DOC18/402415-04

RE: Modification 16 – MP 06_0228 – Shoalhaven Starches Ethanol Expansion Project

Attachment A: EPA Review of MOD 16 – Shoalhaven Starches

EXISTING APPROVED PLANT – BLACK.
PROPOSED NEW #8 BOILER/GENERATOR SET,
LIME SILOS & RELOCATION OF
#7 BOILER –RED.

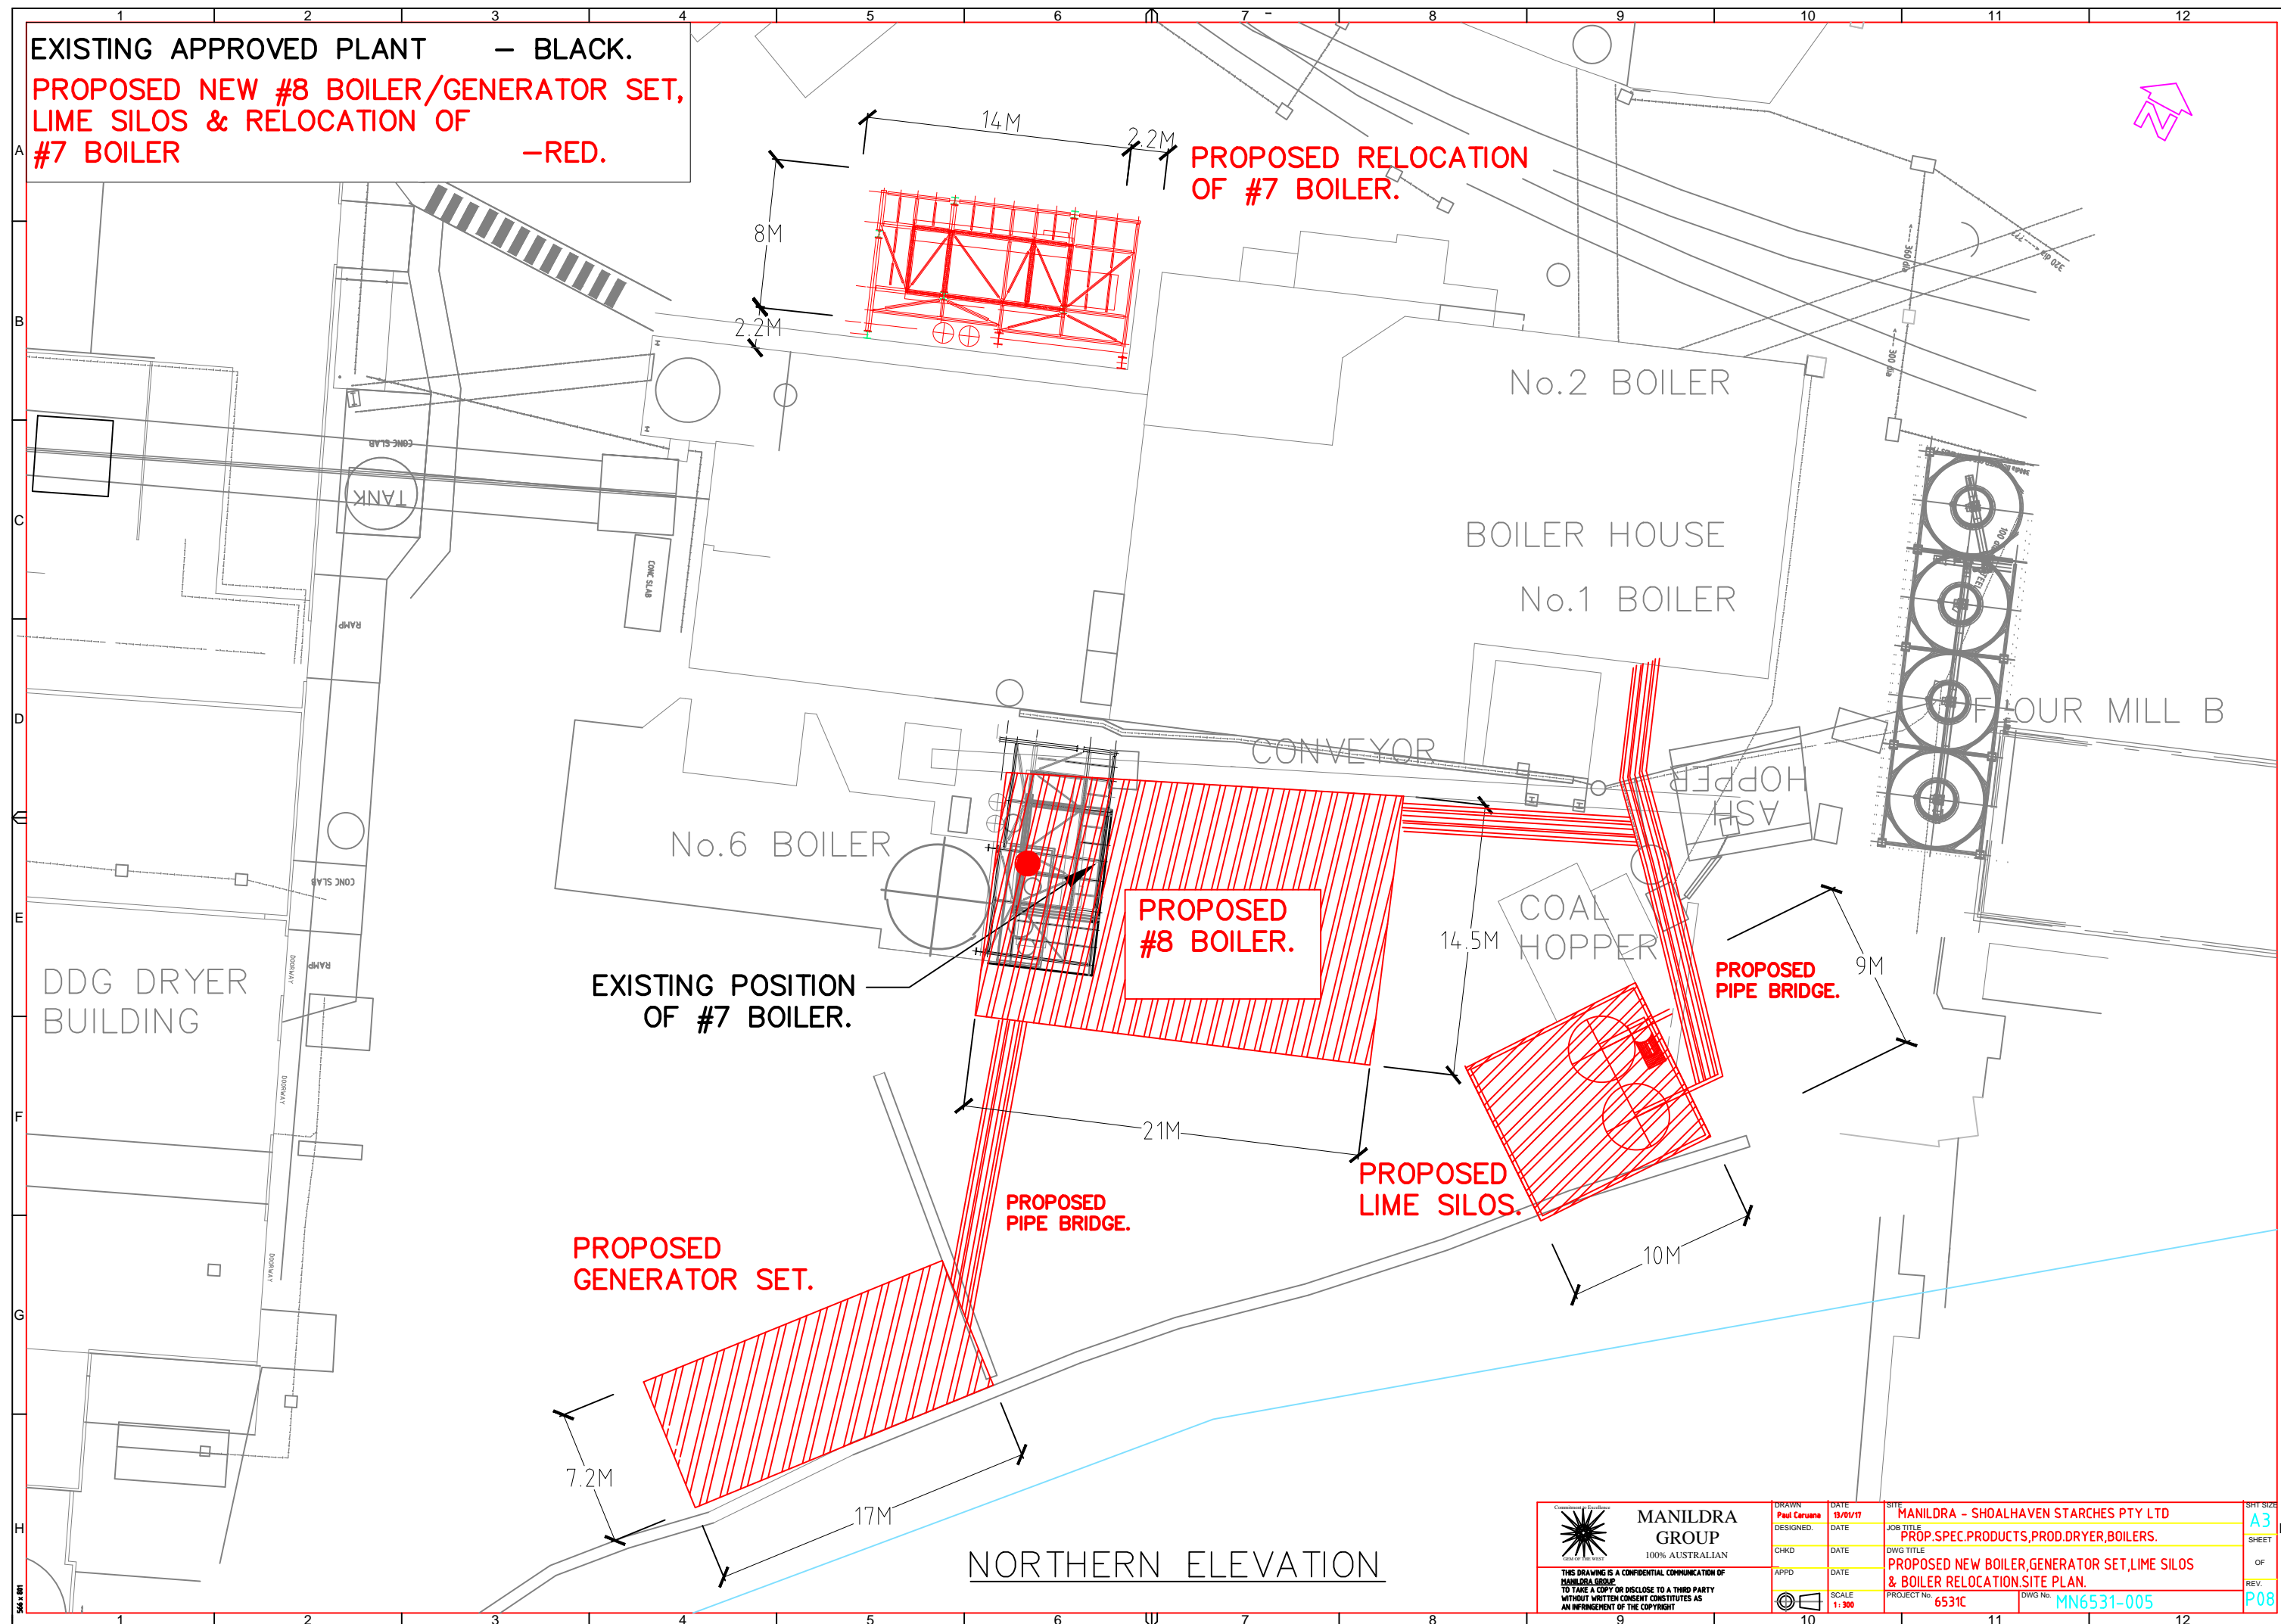
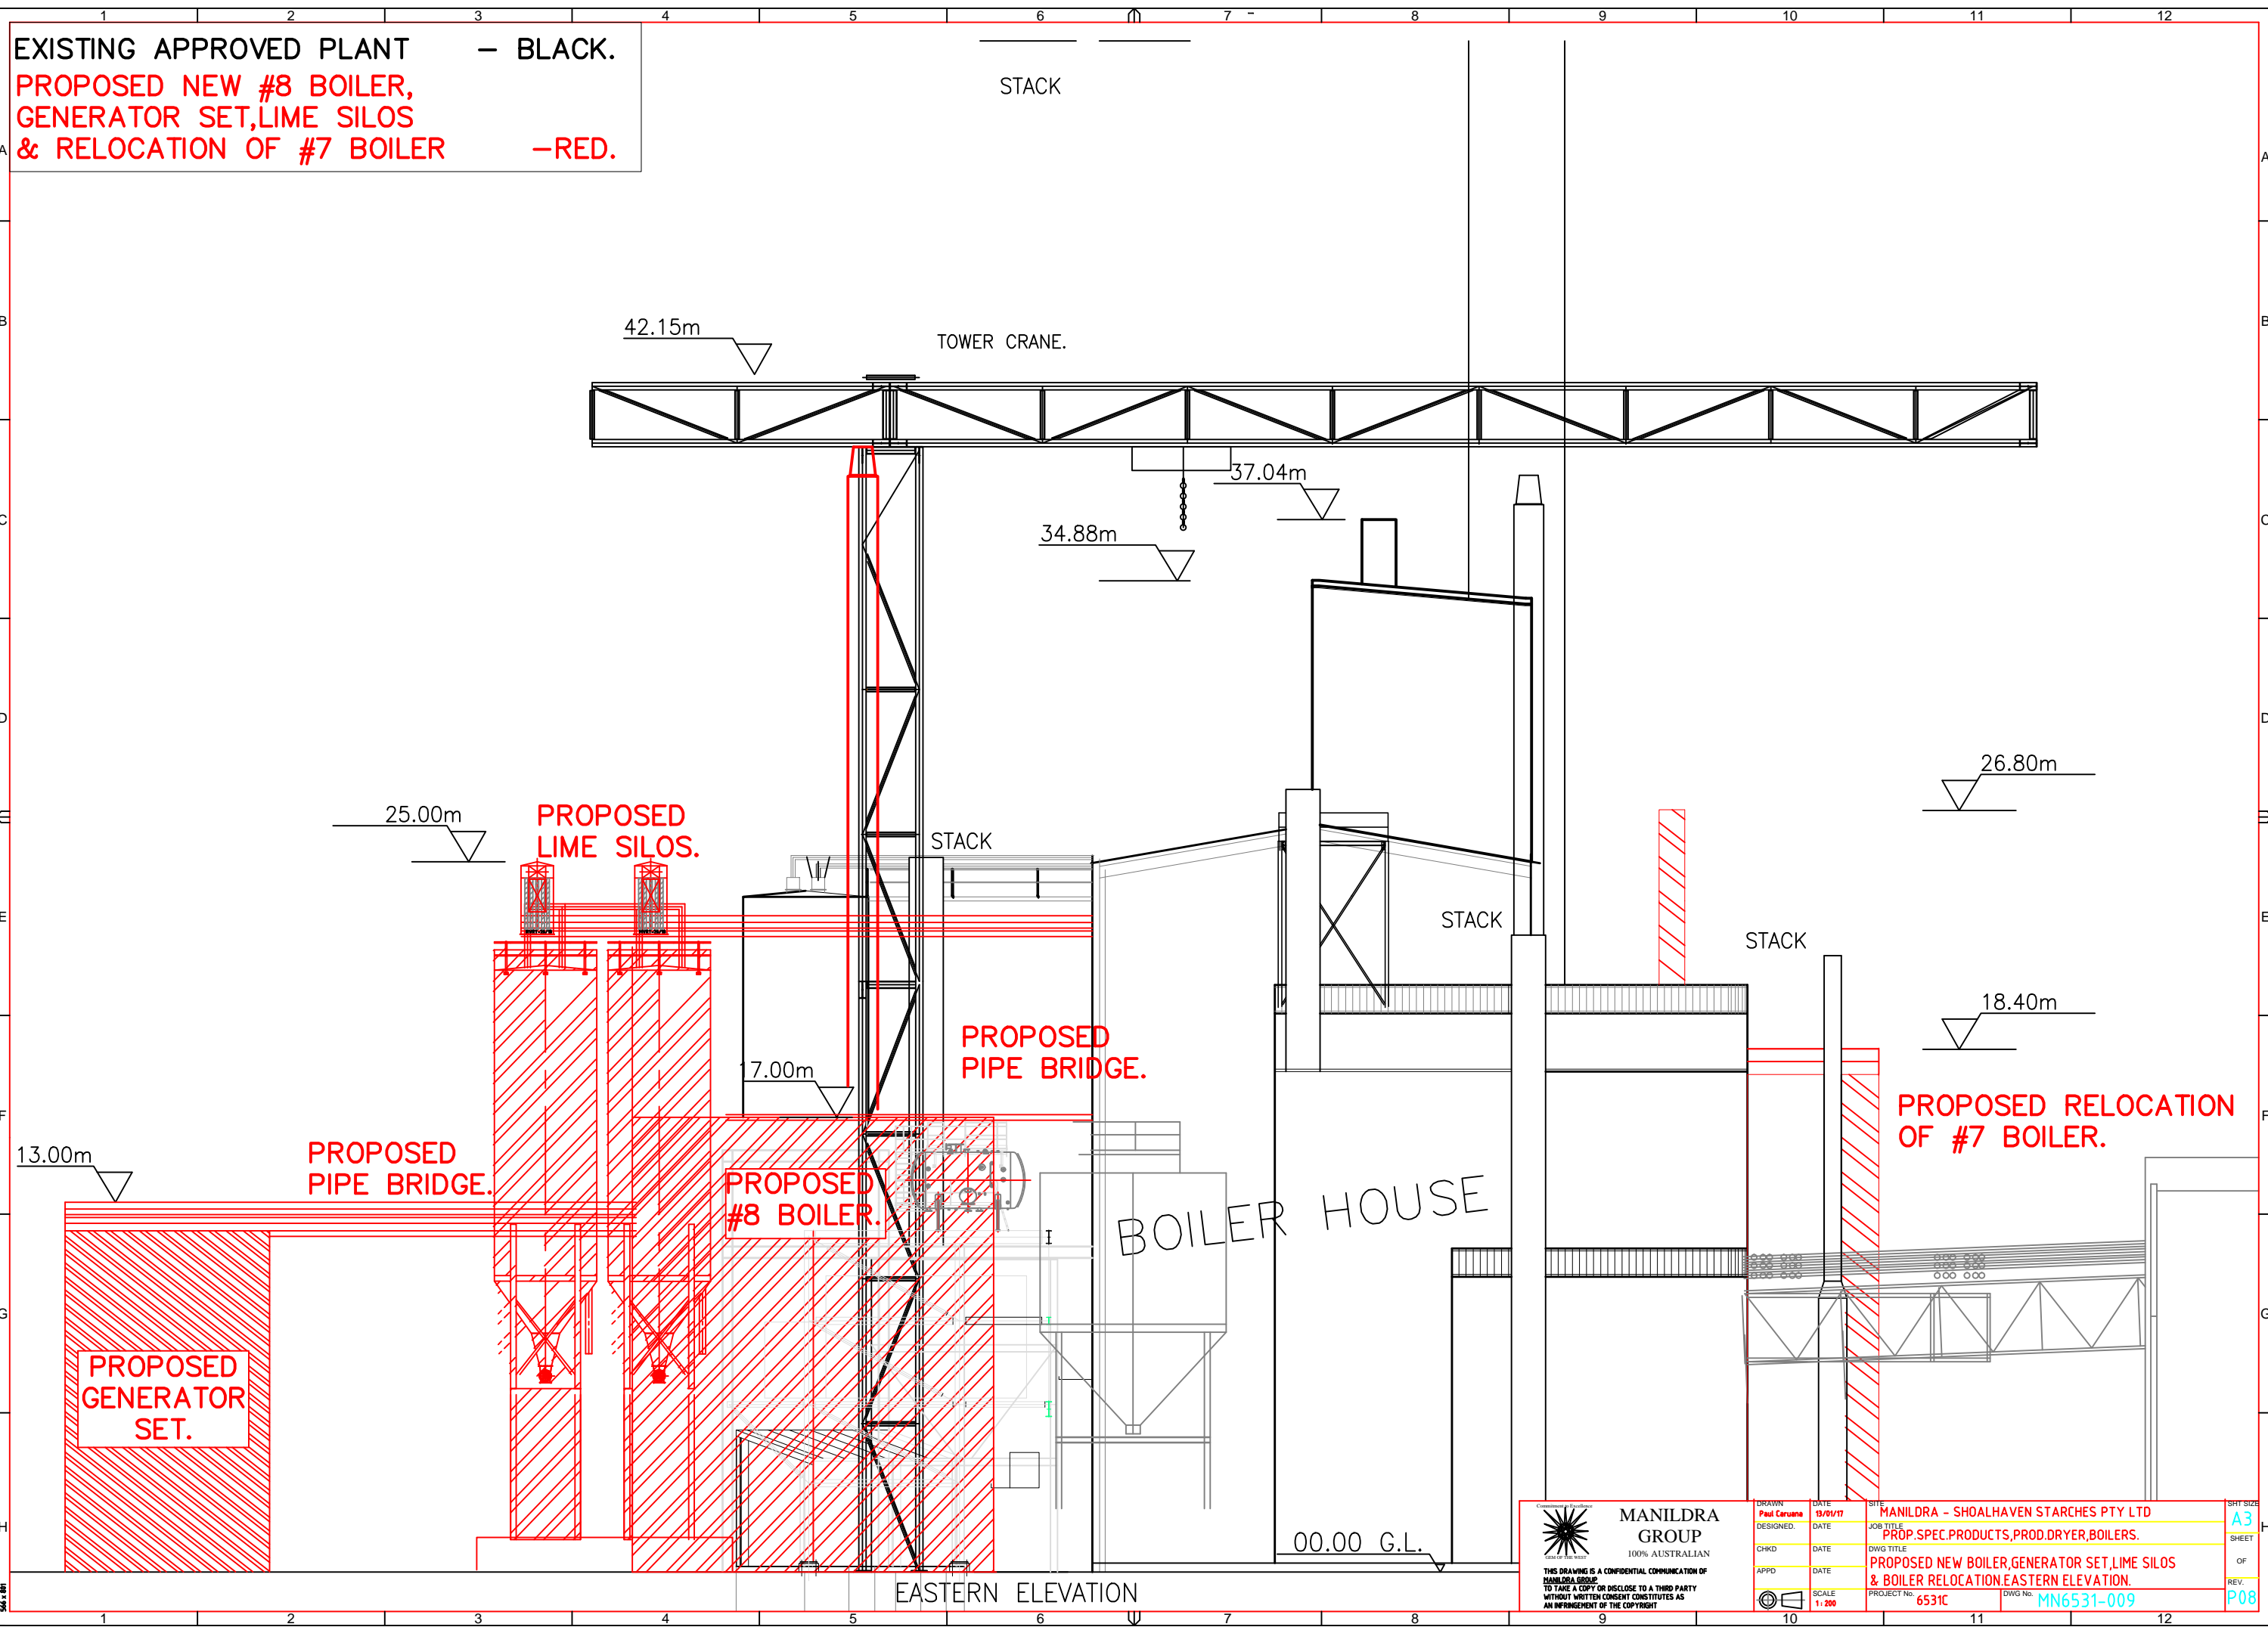
The EPA understands the proposed modification includes the relocation of Boiler 7. The emissions inventory as per Table 8-1 and Table 8-2 does not tabulate emissions from Boiler 7. On this basis it is unclear if Boiler 7 has been included within the impact assessment.

The EPA understands the proposed modification includes the relocation of boiler 7. The assessment advises that:

- 236,520 MJ of biogas would be combusted in Boiler 7. It is unclear if this is a change in operation of boiler 7;
- Emission factors have been adopted from NPI emission estimation technique manual for combustion in boilers.

The EPA advises that it is unclear if the proposed combustion of biogas represents a change in fuel for this source. Additionally, as boiler 7 is an existing source that is proposed to be relocated, then monitoring data should be available. Source specific monitoring data is more appropriate than emission factors for existing sources.

- ***Include assessment of emissions of relocating boiler 7;***
- ***Provide further clarity on the turbines listed within the emissions inventory;***
- ***Include all existing and proposed Gluten and Starch dryers in the particulate and other combustion products emission inventory.***

- **Base existing emission rates for existing sources on available monitoring data**
- **Where monitoring data is not available, justification for the emission estimation for existing sources be provided**
